Date: 21 November 2025

Application by Beacon Fen Energy Park Limited for an Order Granting Development Consent for the Beacon Fen Energy Park Project
Deadline 4 Submissions for Lincolnshire County Council (LCC)

Post Hearing Submissions

Appendix 3 – Permissive pathway indicative route

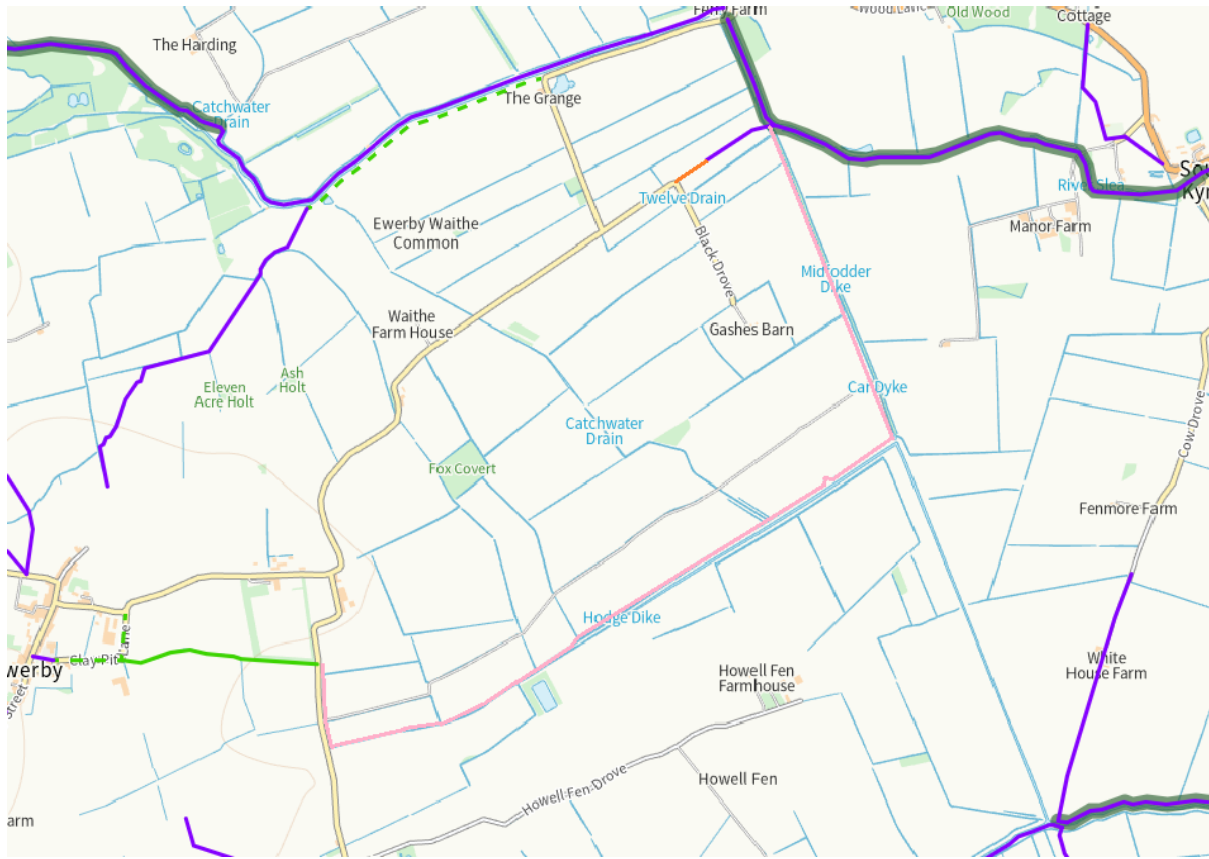
The oPRoWMP has been produced in consultation with LCC's Countryside Service and the provision of a new footpath bridge to link Ewerby to South Kyme is particularly welcome. However, we note it is proposed to be decommissioned at the end of the development. To provide lasting benefits to the network we would wish to see this bridge crossing retained in perpetuity.
